Re: Case No. 313220 – ‘Dundrum Village’ Strategic Housing Development at former Dundrum Shopping Centre, Dublin 14.

The National Transport Authority (the “NTA”) has reviewed the above Strategic Housing Development planning application and, based on the *Transport Strategy for the Greater Dublin Area 2016-2035* (the “Transport Strategy”), wishes to submit the following comments.

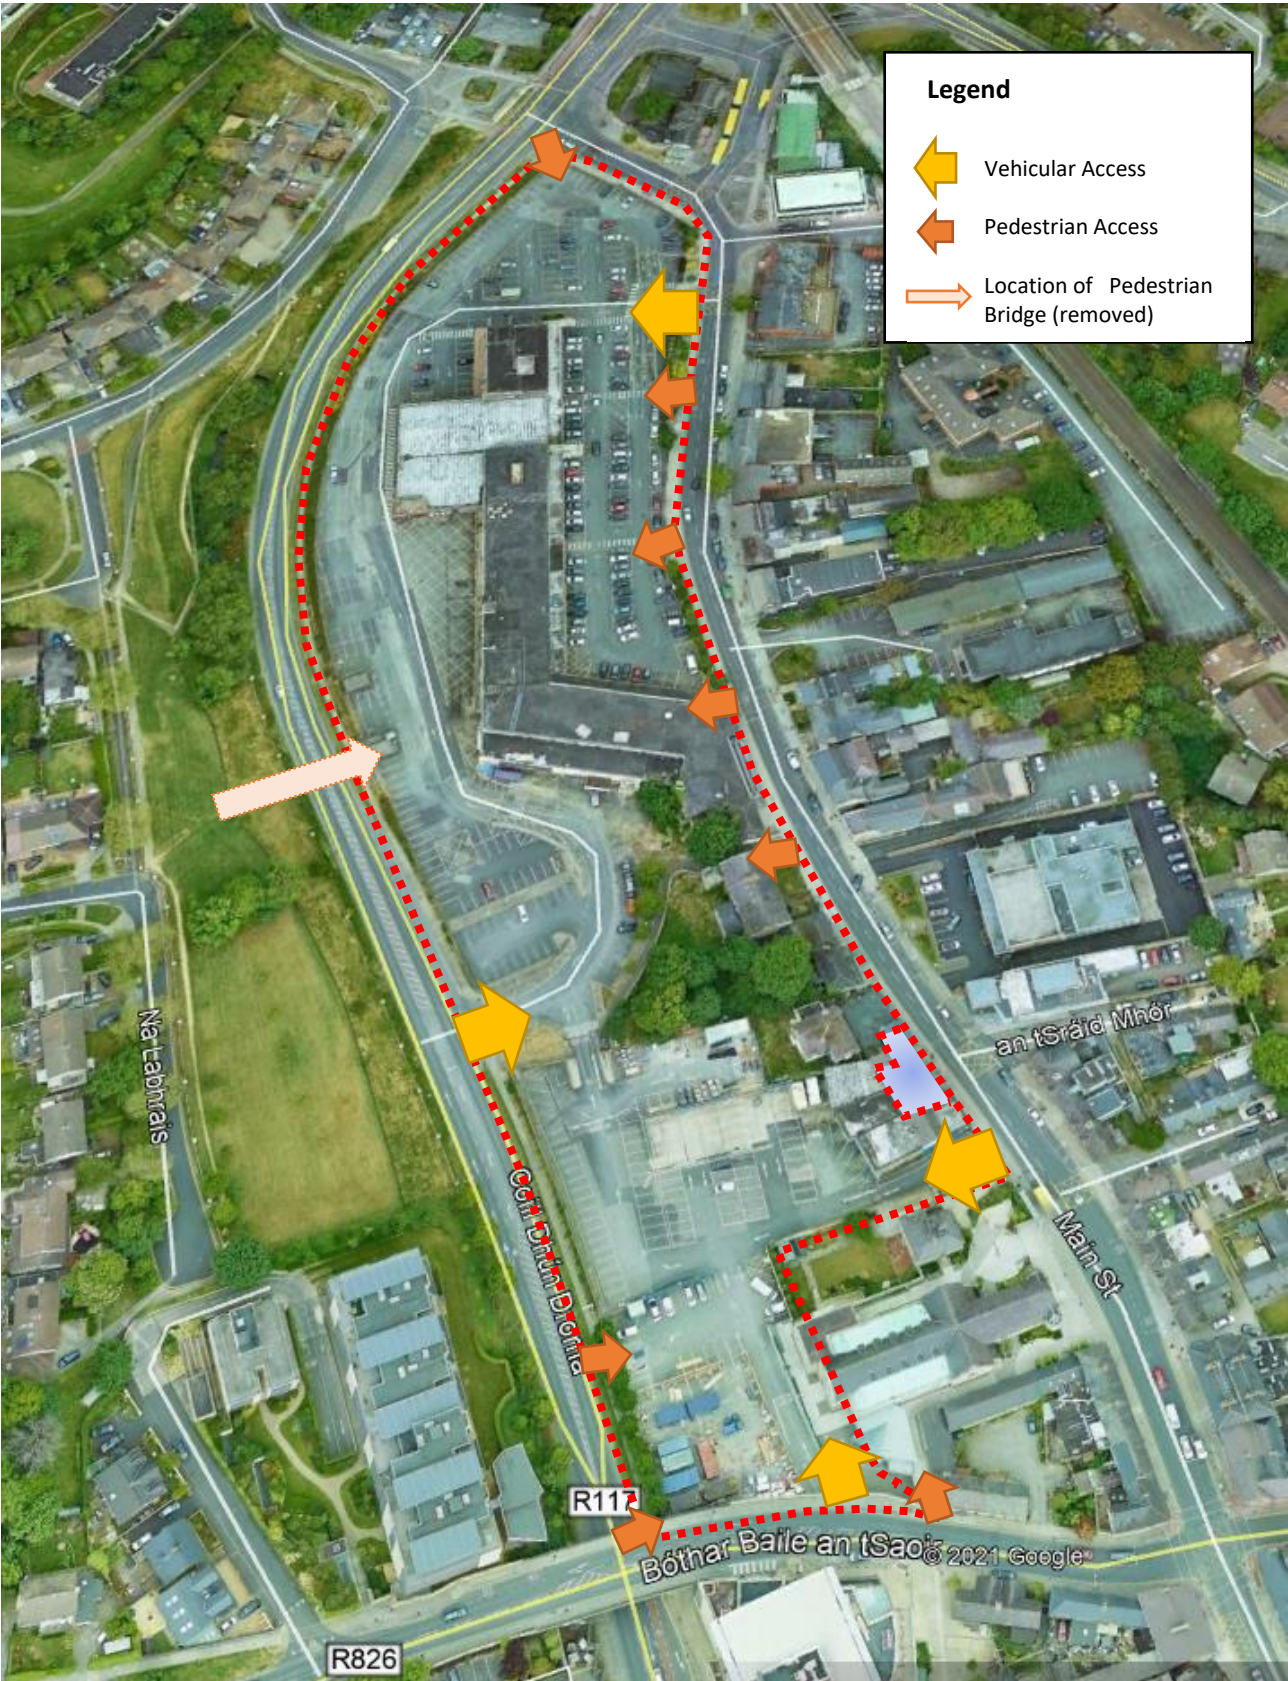
The NTA has reviewed the drawings submitted with the subject application and notes that the proposed bus facility on the bypass has not been included. A vehicular access that serves the retail element of the subject development at the northern end of the site, which also provides for HGV delivery, has been shown at the location required for the bus facility. The conflict between the bus facility and this proposed vehicular access was raised in discussions between DLRCC, the NTA and the applicant prior to the submission of the planning application. While the NTA is supportive of the applicant's intention to concentrate vehicular access to the site on the bypass, which would reduce traffic volumes on Main Street, the conflict at this location is a matter of some concern to the NTA as it is not clear how the proposed vehicular entrance could be implemented with the bus facility in place.

In the event of a grant of planning permission for the subject application, the NTA would welcome a condition that:

- a) requires the applicant to liaise with the NTA and DLRCC to agree an alternative arrangement for the planned bus facility, and
- b) states that the use of the proposed northern vehicular site access would be dependent on the satisfactory resolution of this issue.
